10 May 2016

**Re: SSD 7021 MIXED USE COMMUNITY AND RETAIL BUILDING AND PUBLIC SQUARE
WITHIN THE NORTH PLOT (DARLING SQUARE, HAYMARKET)**

RETAIL PODS PLAN

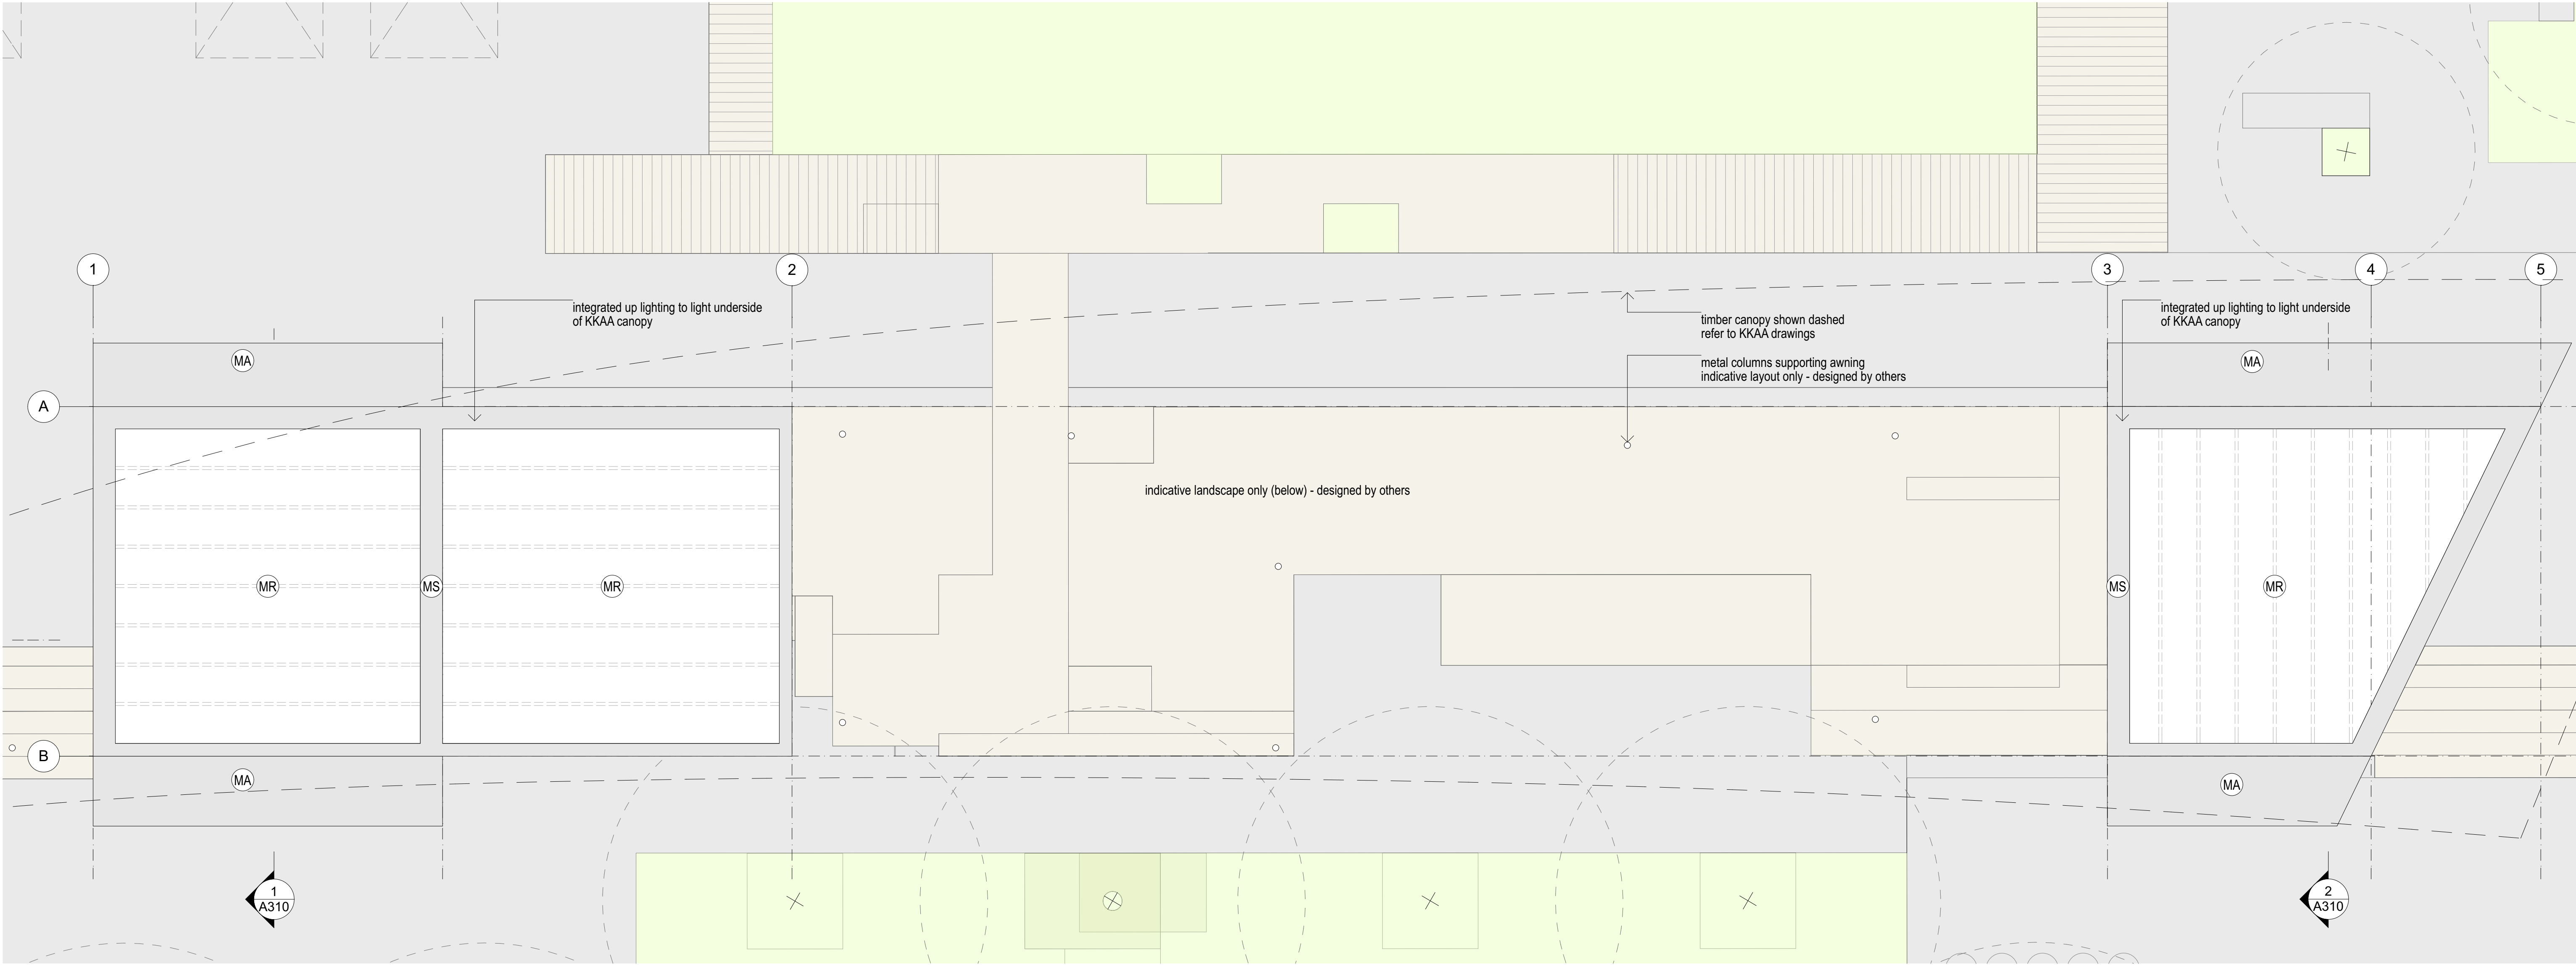
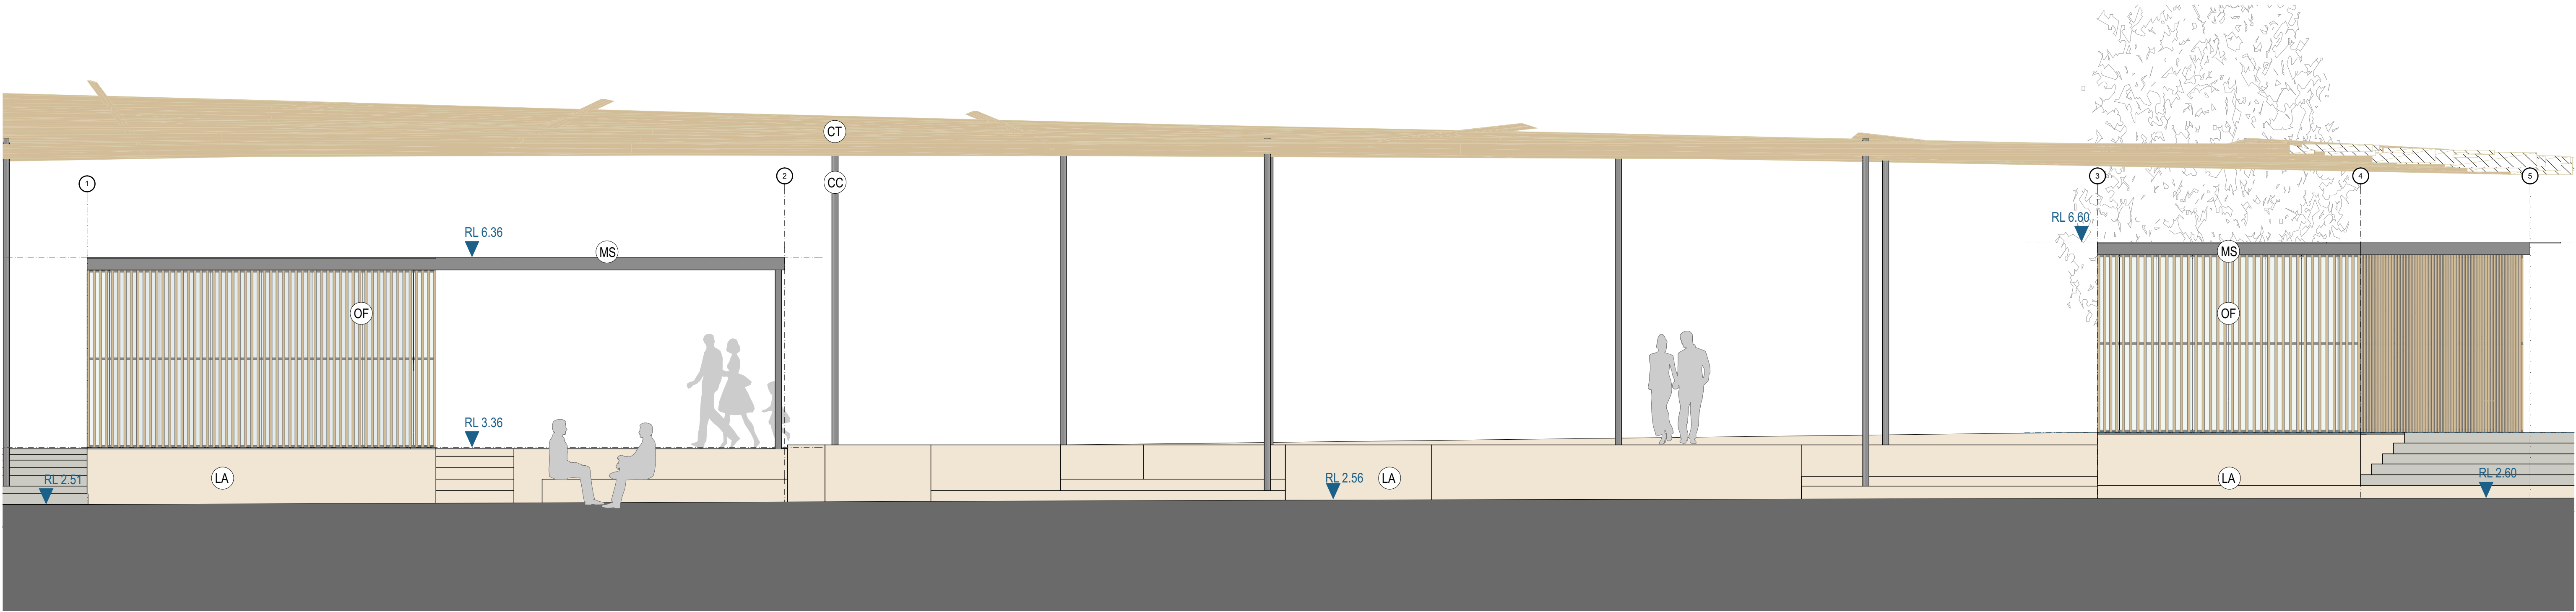
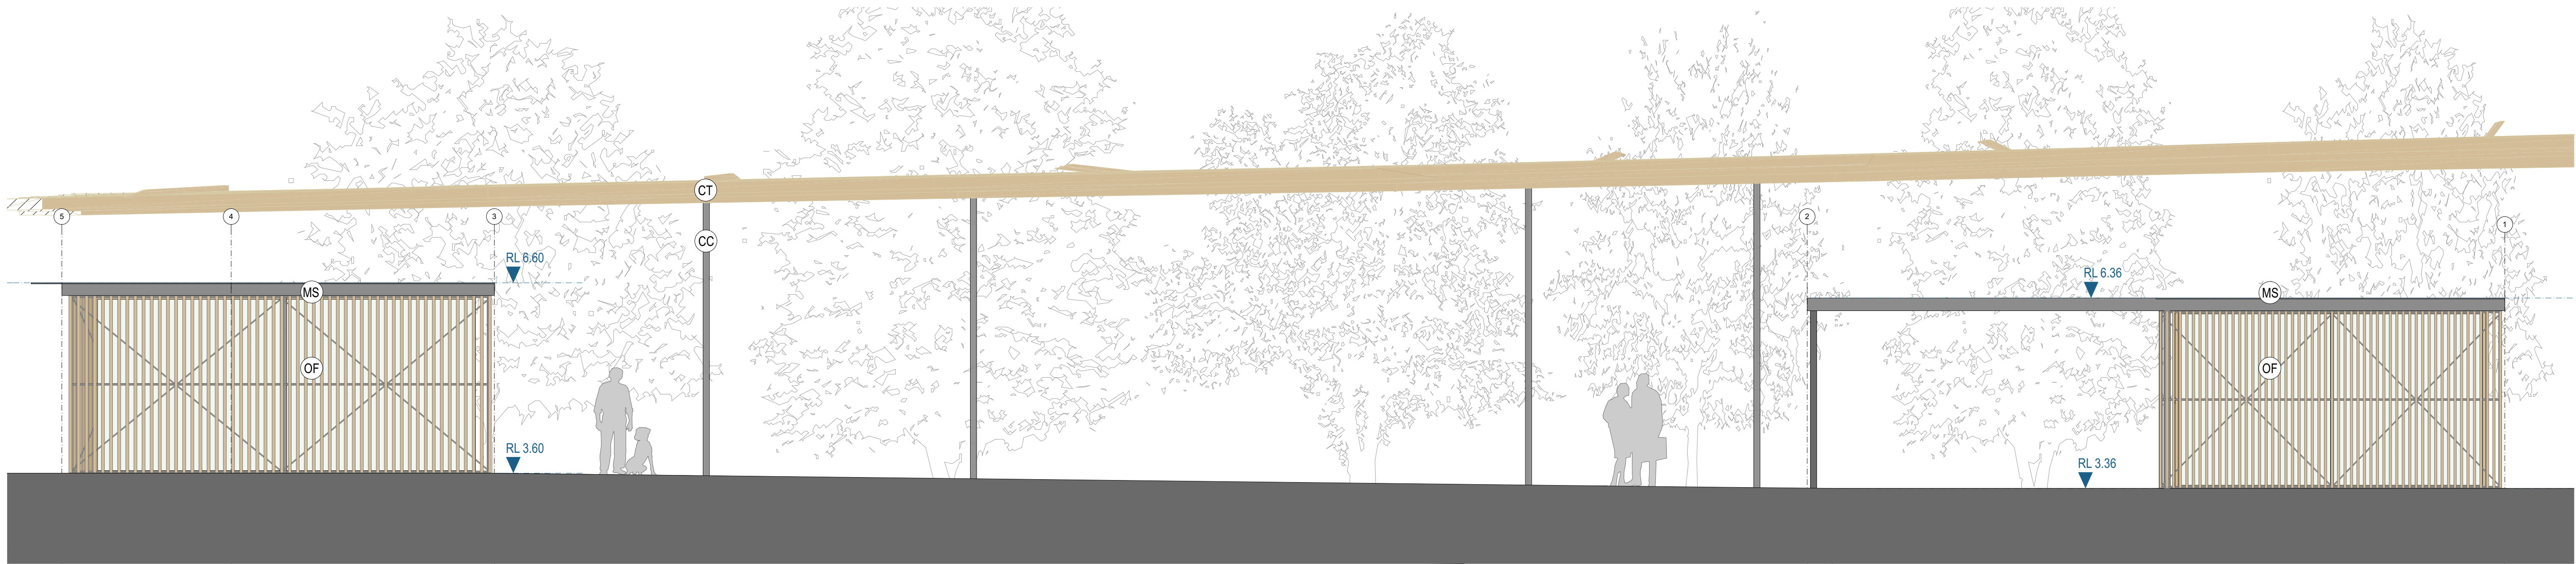
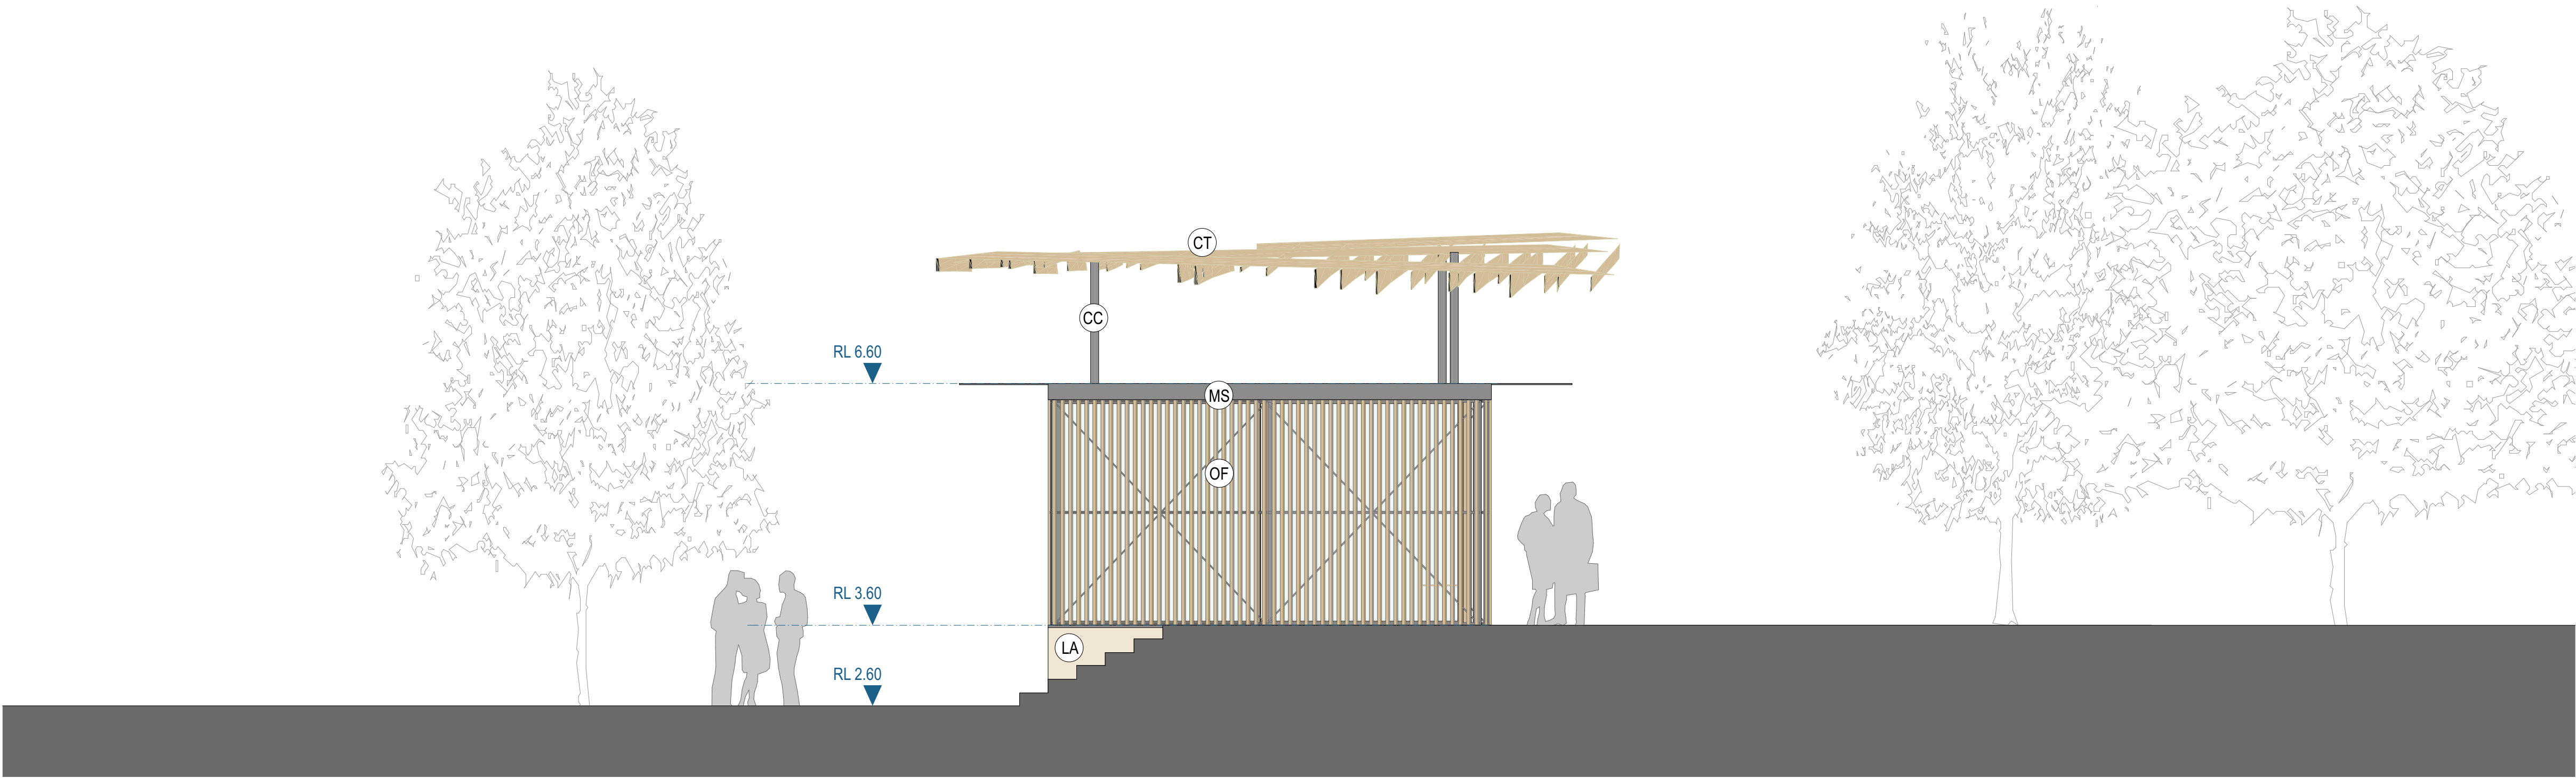
In addition, two permanent retail 'pods' are proposed to aid activation to both the Square and the Boulevard. Although activation of the public domain is supported, it is considered that the planned retail component on the ground floor of the Exchange Building, coupled with the organised markets and outdoor events on Haymarket Square will provide adequate opportunities for activation of the public domain. Accordingly, the introduction of retail pods on Haymarket Square is considered excessive and creates unnecessary visual clutter.
